One Earth Solar Farm

**Draft Statement of Common Ground with the Environment
Agency**

EN010159/APP/8.11

August 2025

Appendix B Example Trenchless Crossing Cross-Sections

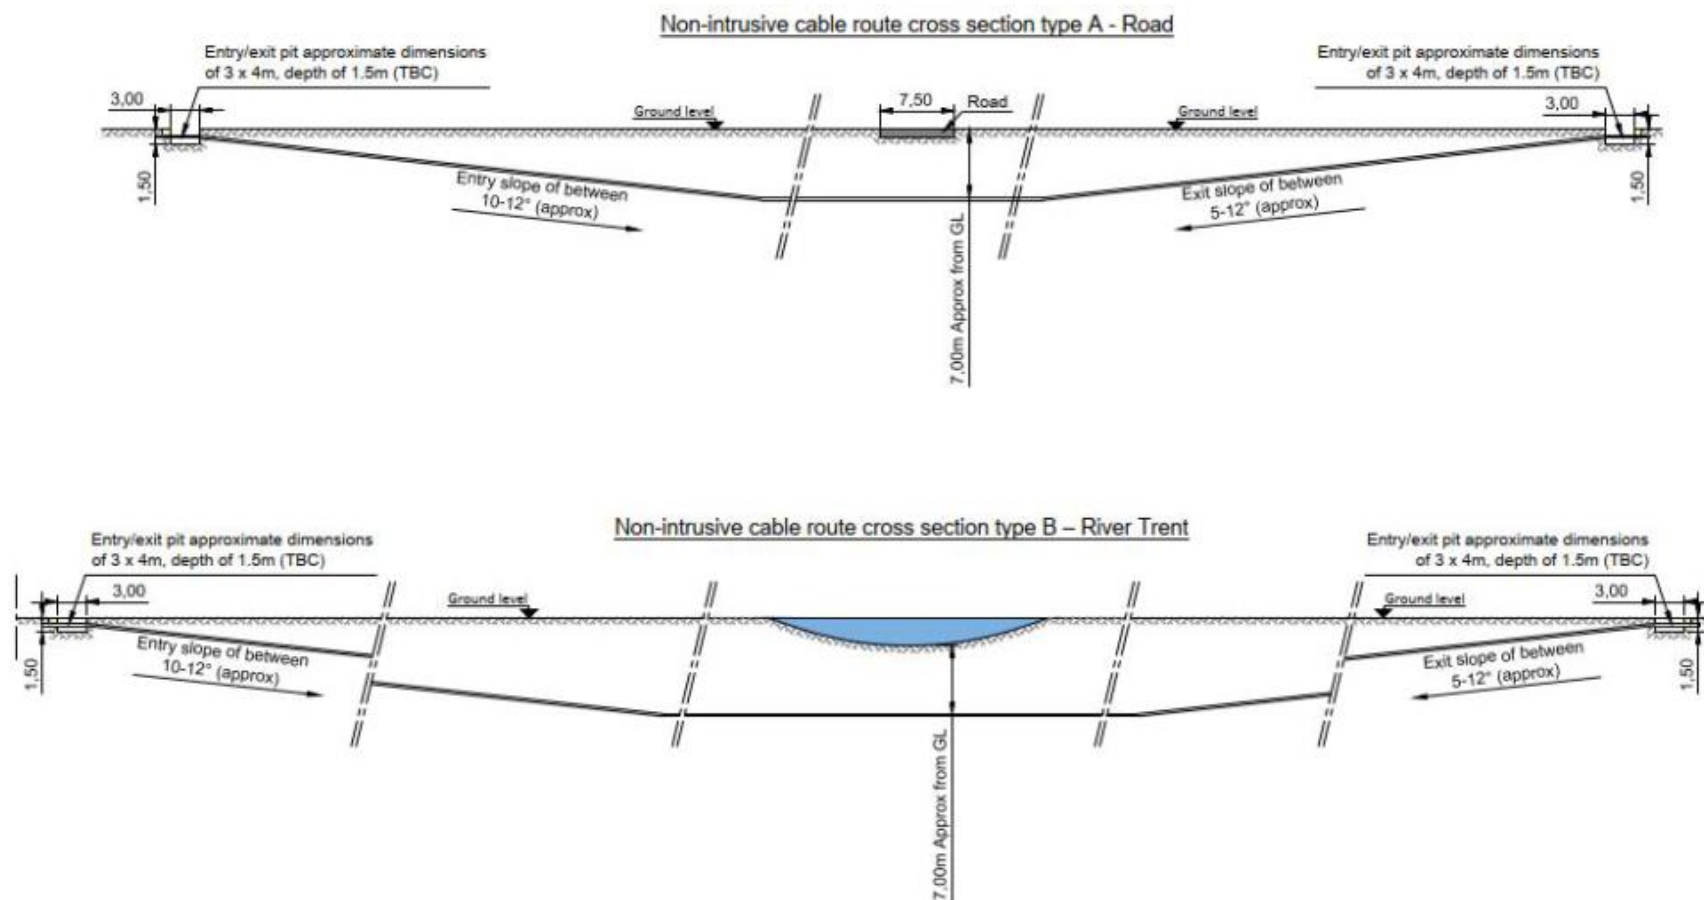
02-06	Cable Crossings beneath Main Rivers	Applicant to consider the impacts of cable crossings beneath Main Rivers and existing flood defences.	<p>The proposed cable crossing beneath the River Trent will be undertaken using trenchless techniques and specific construction processes will be set out within the CEMP.</p> <p>A hydromorphology survey, river bed survey and hydrogeological risk assessment to be undertaken to inform the design of the cable crossing beneath the River Trent.</p> <p>Surveys of the existing flood defences will be undertaken at detailed design if deemed required. Furthermore, monitoring of the flood defences can also be undertaken during construction if deemed necessary.</p>	<i>Under Discussion</i>
02-07	Maintenance Plans	Applicant to set out outline maintenance activities that will be undertaken to ensure there is limited potential for blockages to floodplain and the development maintained adequately.	<p>Specific maintenance required for the panel frames and inverter structures (following a flood event) will be set out at detailed design and included in the OEMP. However, likely to include the following as a minimum:</p>	<i>Under Discussion</i>
